Our Ref: AL/45/18/PL

**Town & Country Planning Act 1990 (as amended)
Town and Country Planning (Development Management Procedure) (England) Order 2015
Application for Planning Permission**

Development Side extension to enclose existing plant/machinery.

Location Global Technologies Racing Ltd Denmans Lane Fontwell

PROPOSED WEST ELEVATION

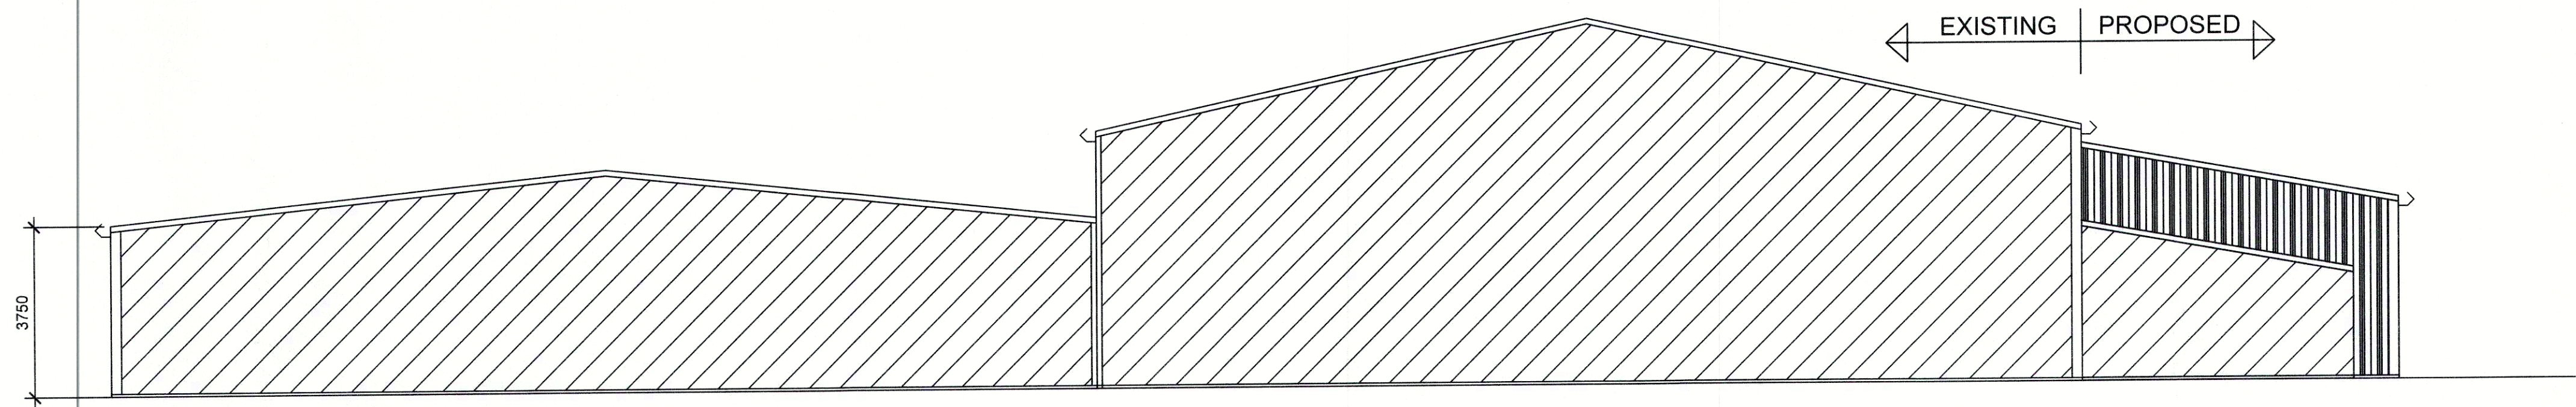
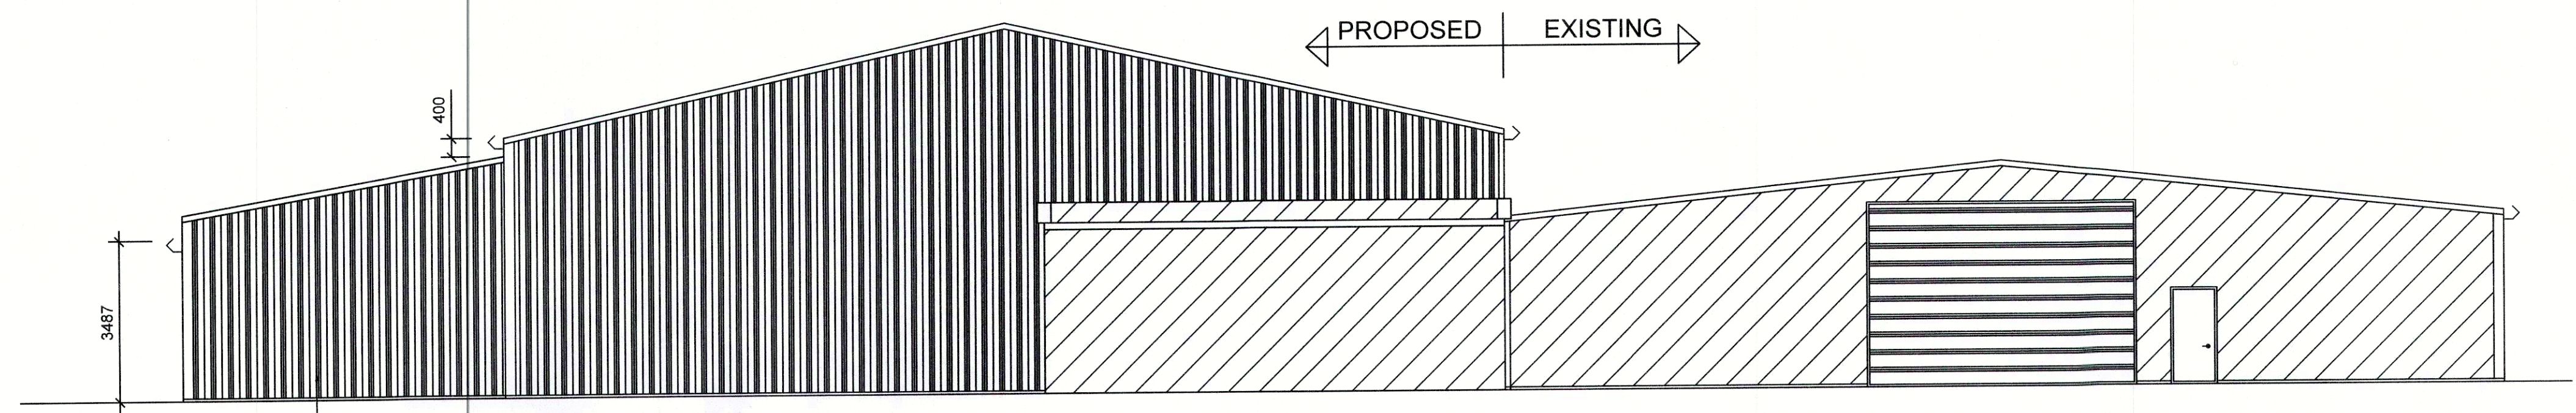
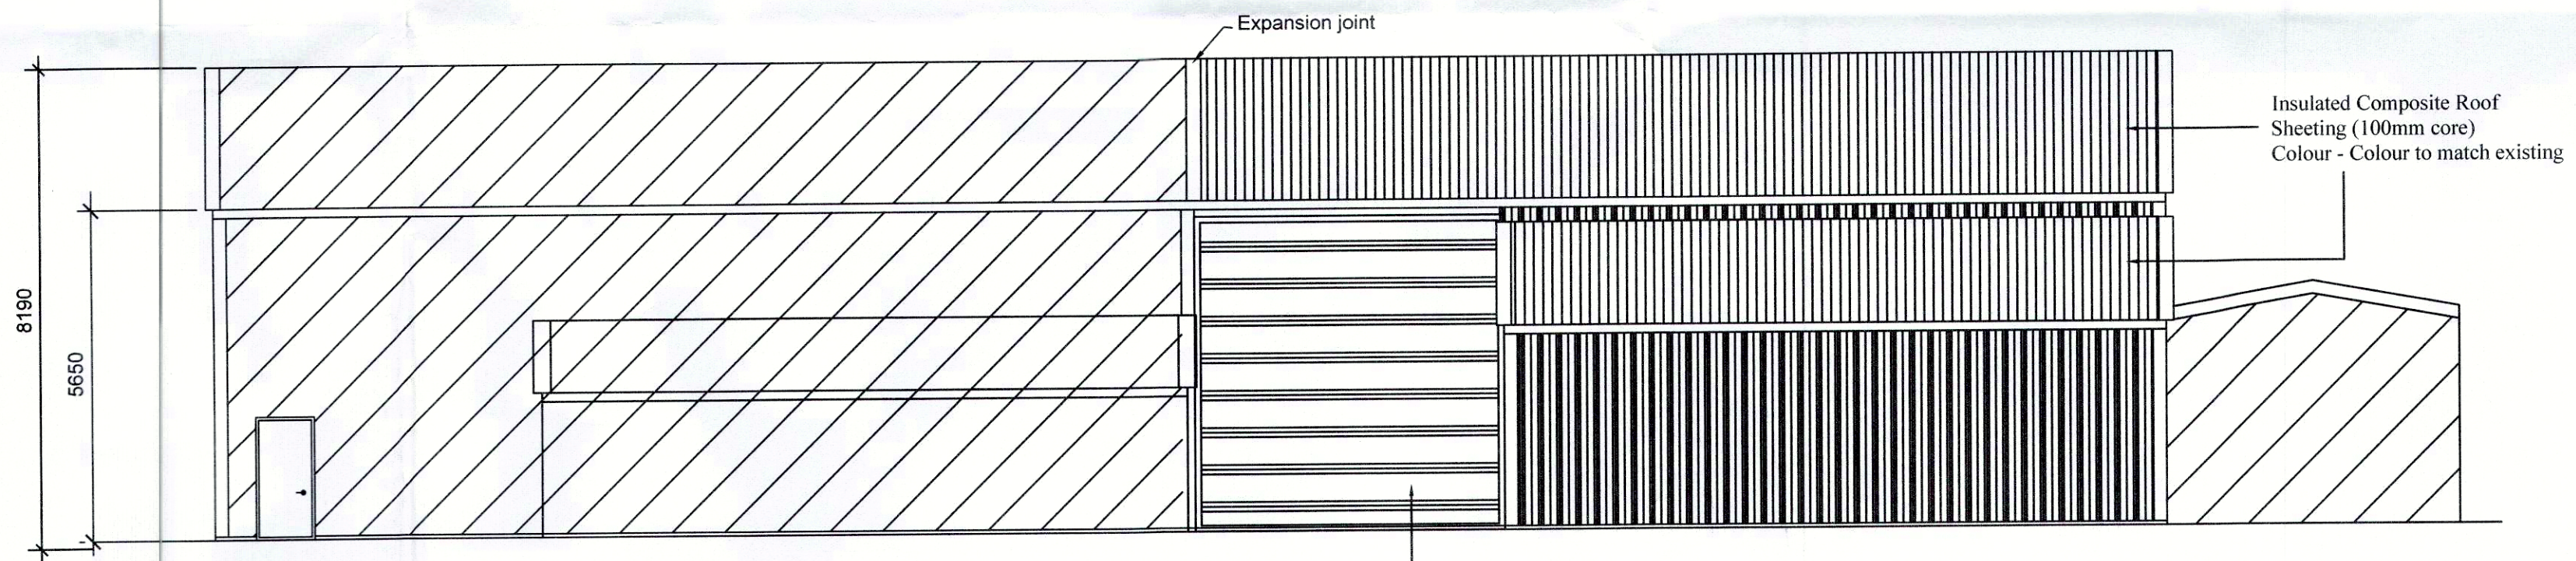
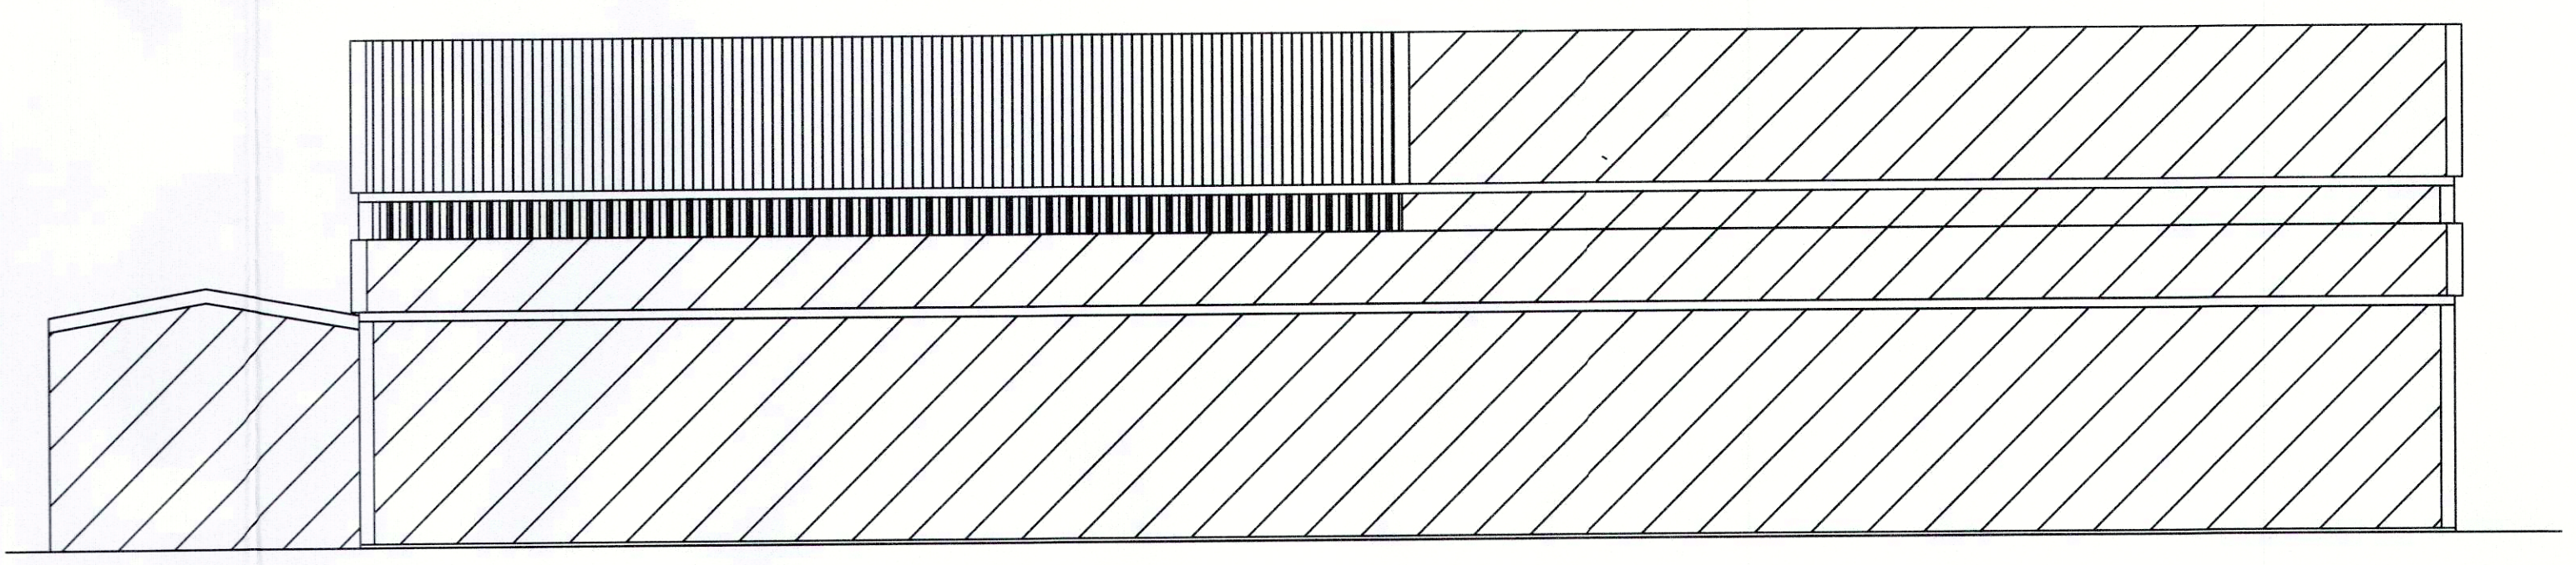
Please provide a proposed west elevation.
